Your Ref: OWQC4251
Our Ref: BE/120/14/HH
Please ask for:
Mrs J Chapman

14th November 2014

Two storey side & single storey rear extensions (resubmission following BE/68/14/HH).
13 Newtown Avenue Bognor Regis

Proposed Front Elevation (South)

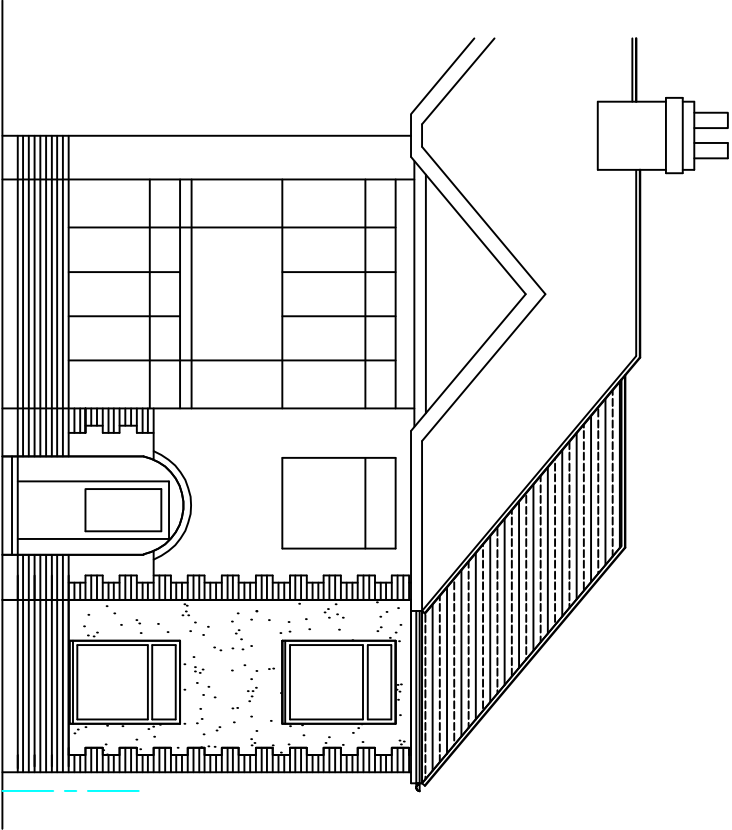
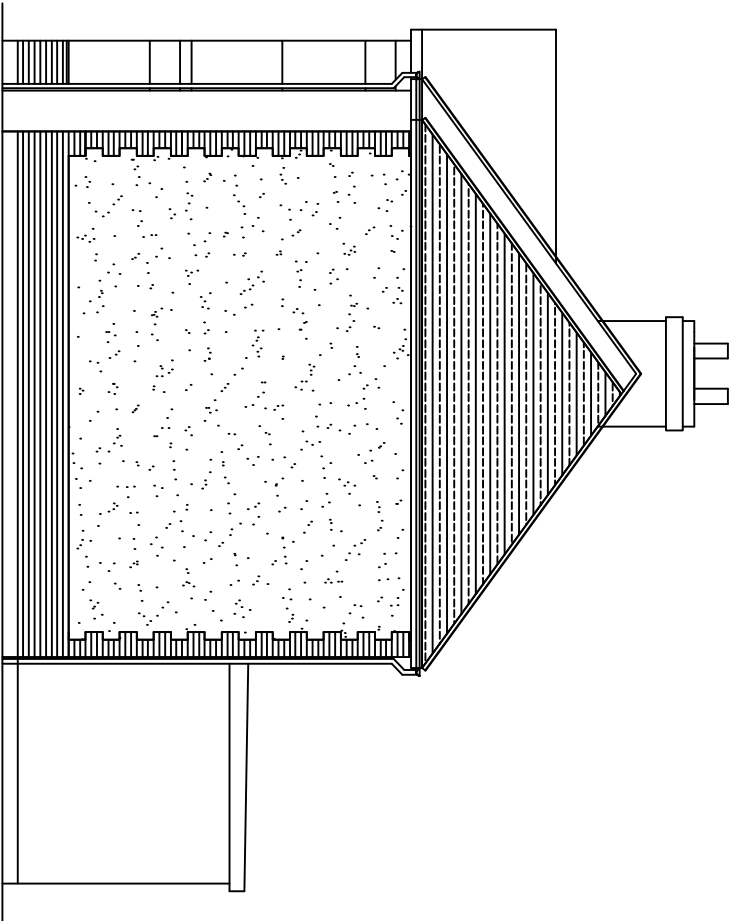
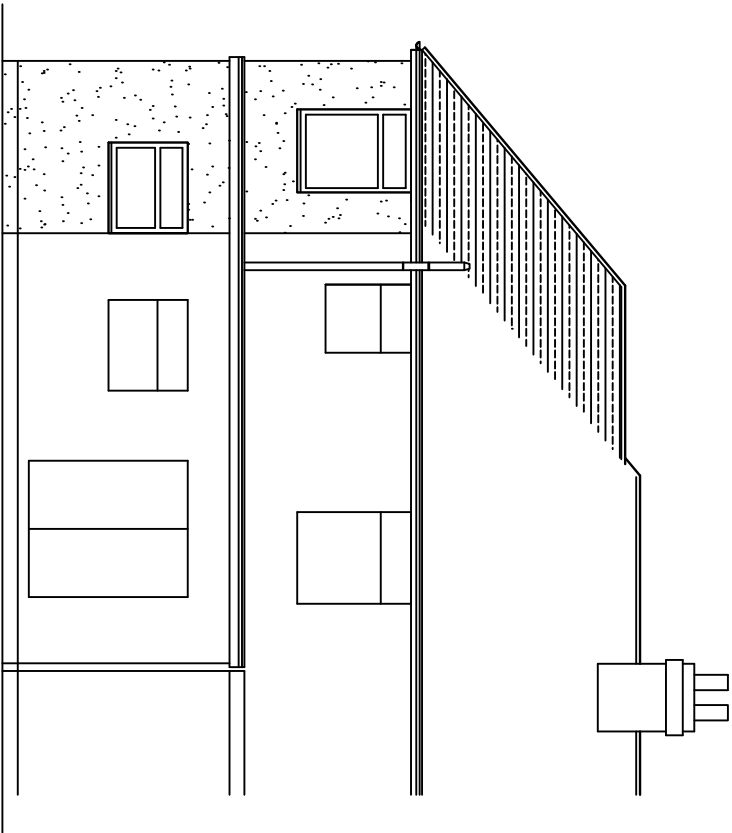
*OBJECTION on the grounds that the
extension build does not conform to the policies of the Bersted NP in the following ways:
ES1 the design does not contribute to the street scene and still is too close to the
neighbouring house
HDQ2 the extension does not integrate with surrounding houses
Plus the loss of the garage means extra parking on an already over-stressed street scene.*
